07 May 2012

Re: Exhibition of Environmental Assessment for Port Waratah Coal Services Terminal 4 Project (MP10_0215) .

Council officers have reviewed the submitted EA and it is recommended that the Department's consideration of the application stand deferred pending the proponent submitting supplementary information which satisfactorily addresses the following issues:

Future site access plan showing proposed intersection improvements

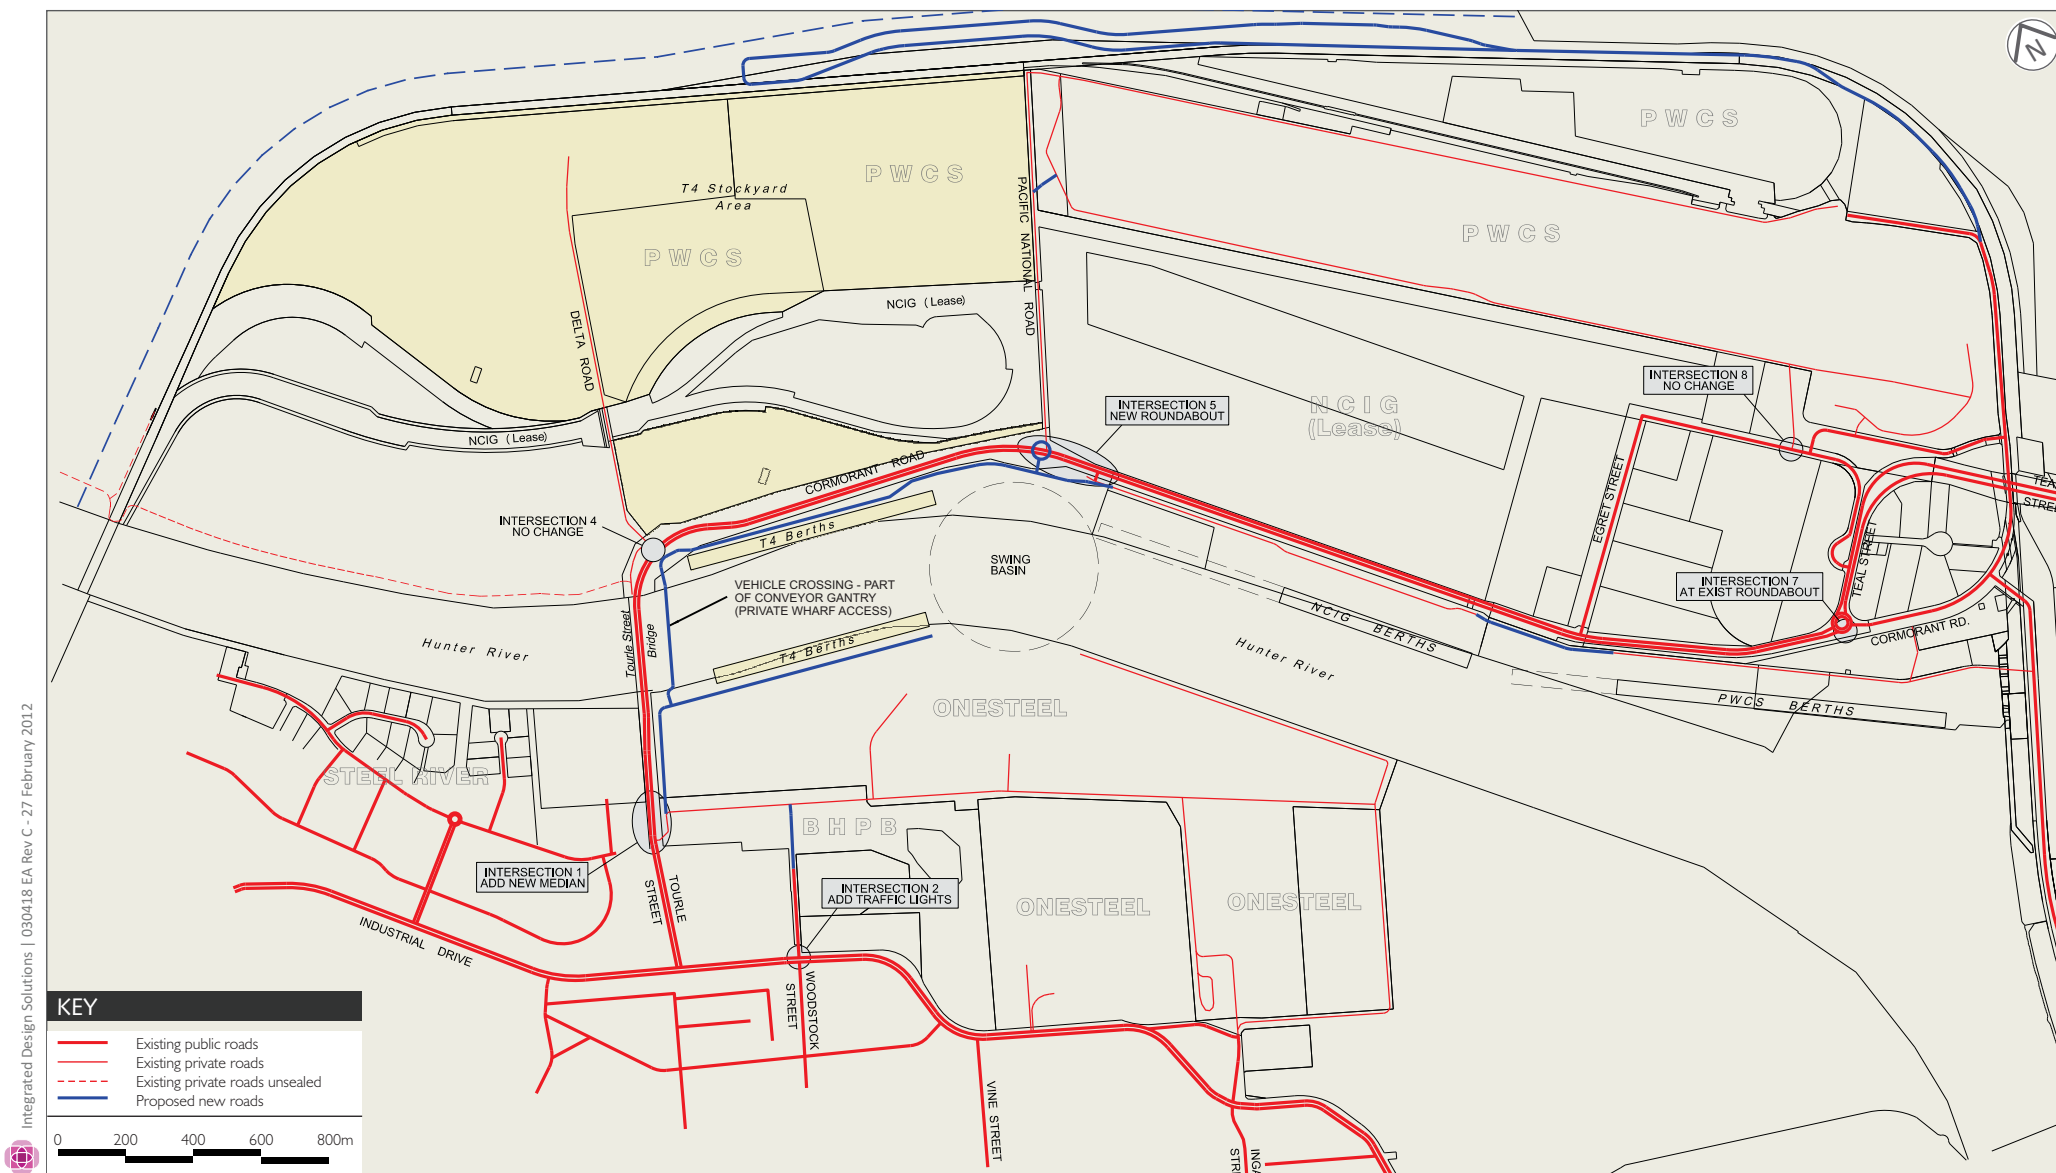
Vehicular access to the southern bank wharf area is dependant on the proponent obtaining the agreement of a number of different land owners. These agreements will in turn determine the access location onto Industrial Drive, either Woodstock Street or an alternate location to the east. These agreements should be obtained prior to determination of this application and the location of the access to industrial Drive confirmed and modelled to determine adequacy.

In this regard, concern is raised in relation to the close proximity of any proposed traffic signals at Woodstock Street to the signals at the Industrial Drive / Tourle Street intersection. Traffic modelling should be undertaken to determine that these signals would function without adversely impacting on Industrial Drive.

The longitudinal grade of the northern leg of Woodstock Street on approach to Industrial Drive is not considered desirable for heavy vehicle activity. It is therefore recommended that the proponent investigate the option of accessing the southern bank wharf area via Vine Street or alternatively Ingall Street.

Notwithstanding the above, should traffic signals be installed at Woodstock Street it is recommended that it only operate as a traffic signal controlled T- intersection with the southern arm of Woodstock Street being closed to all traffic to protect residential amenity. Any such road closure would require community consultation.

A roundabout or traffic signals are proposed on Cormorant Drive linking the Pacific National Road and a realigned NCIG access road.

It is recommended subject to RMS concurrence that traffic signals be installed to maximise road safety while permitting greater flexibility to respond to fluctuations in traffic volumes at different times through the variation of signal phasing ('green time').

The RMS are proposing to extend the Tourle Street approach to left turn slip lane into Industrial Drive resulting in the entrance to this lane coinciding with the proposed entry/exit to the southern bank wharf area. Concern is raised in relation to potential for rear end accidents and therefore it is considered that this access either be deleted or restricted to left out only. Further discussions will be required with RMS in relation to this matter.

The proposed central median in Tourle Street to restrict vehicular access is supported, although the length of this median will be required to be sufficient to deter U-turn movements. The length of this median would be determined in consultation with RMS and NCC at the detailed design stage. This median should be constructed prior to operation of the Tourle Street access.
